# LIBERTY TREE ACADEMY SITE DEVELOPMENT PLAN

## TOWN OF PEYTON, EL PASO COUNTY

### FINAL JUNE 2018

SITE PLAN

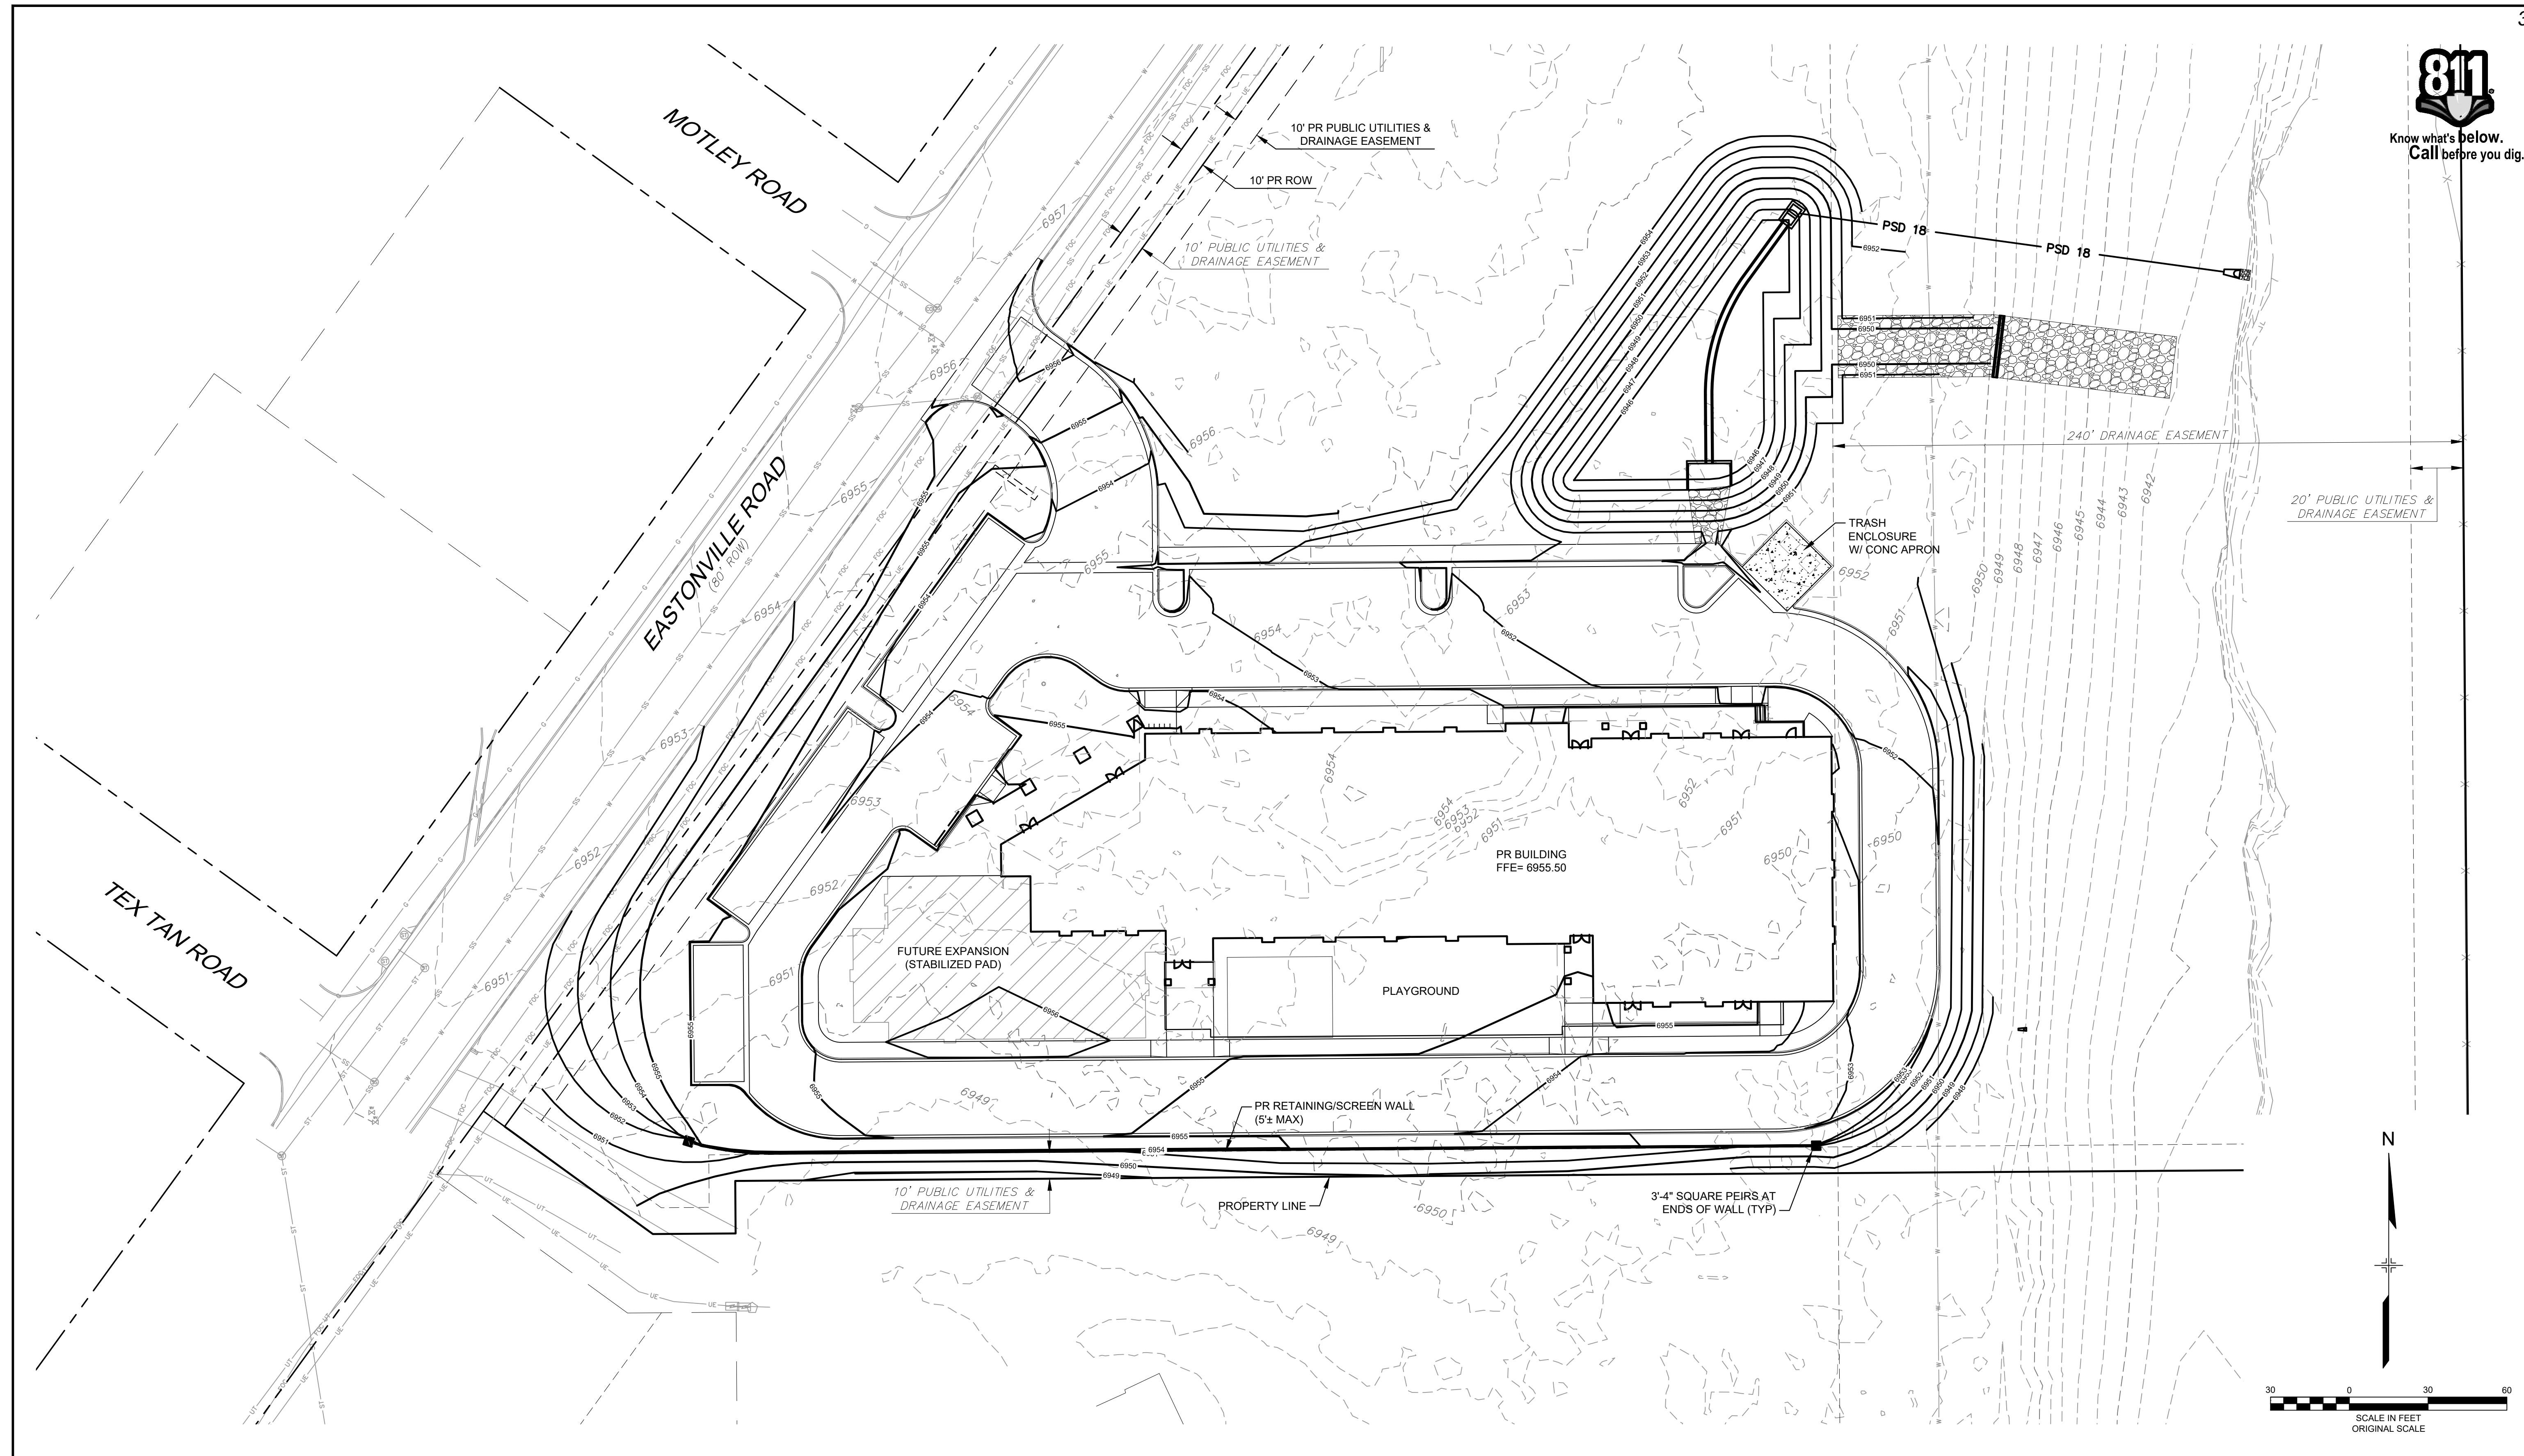
Include a note stating that if and when the future expansion of a high school occurs the necessary parking required for a high school will be added to meet the parking regulations.

Correct, note added.
